KEADBY 3 **CARBON CAPTURE POWER STATION**

Planning Inspectorate Ref: EN010114

**Proposed Development Changes:
Rationale and Need Statement (Deadline
6a Version)**

Date: May 2022

Figure 4.1

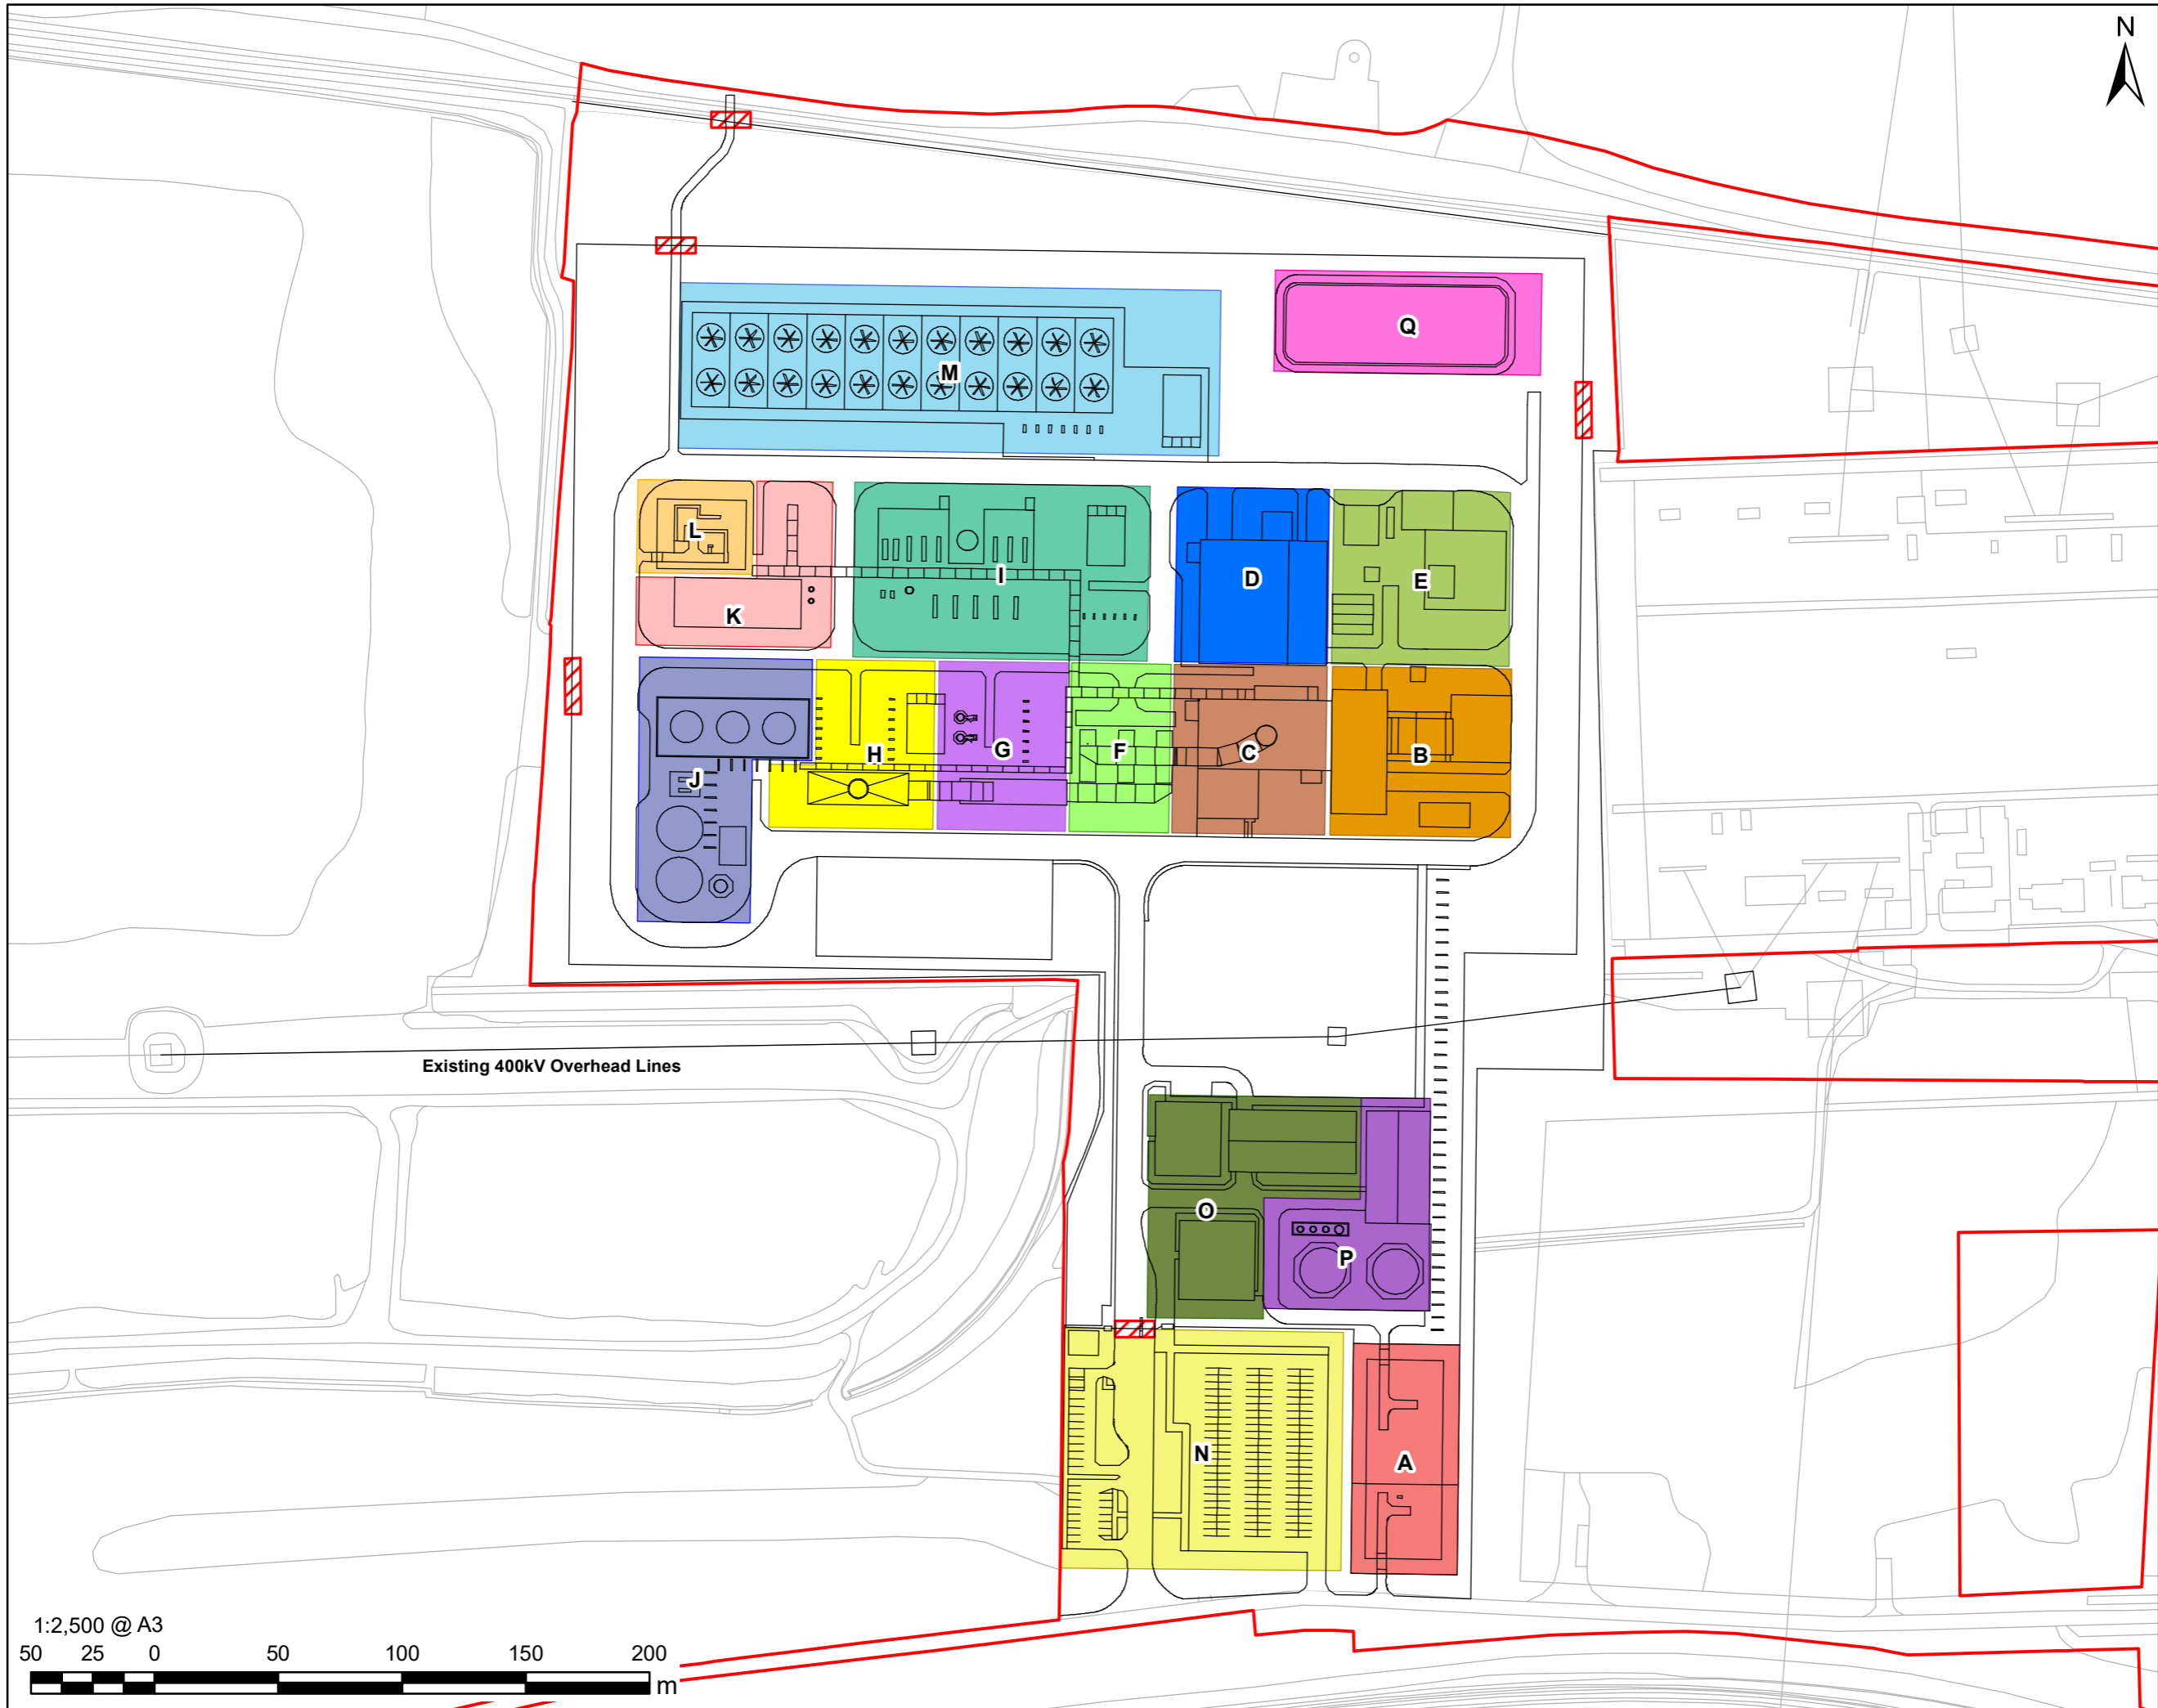
2.3.4 Ongoing engagement with the design contractors has identified that in the event that the option for up to two absorbers is required for the removal of CO₂ from flue gases within the CCP (**Work No. 1C**), the twin absorber units and stacks may have maximum dimensions up to 80m above ground level (AGL) for the absorber towers and up to 15.5m for the stacks i.e. up to 95.5m AGL, which equates to a maximum of 98.3m Above Ordnance Datum ('AOD') for each absorber and associated stack. The maximum dimensions established through ongoing design development are up to 22m higher than those previously assessed in the submitted ES for up to two absorbers/ stacks (denoted in italics in Table 1 below). This change is within the Order Limits (**Work No. 1C**).

2.3.5 Ongoing design development with design contractors has also identified that the proposed CO₂ stripper column (also **Work No. 1C**) may have maximum dimensions up to 63m AGL which equates to a maximum of 65.8m AOD and which is 10m higher than was included as a parameter in the draft DCO submitted with the Application [**APP-005**]

Absorbers (Work No. 1C) (in the case that two absorbers are developed)		19.0 – no change	Up to 80.0 (57.8)	82.8 (60.6)
Twin absorber stacks (Work No. 1C) (in the case that two absorbers are developed)		6.7 – no change	95.5 (75.8)	98.3 (78.6)
Carbon dioxide stripper (Work No. 1C)		15.0 – no change	63.0 (52.8)	65.8 (55.6)
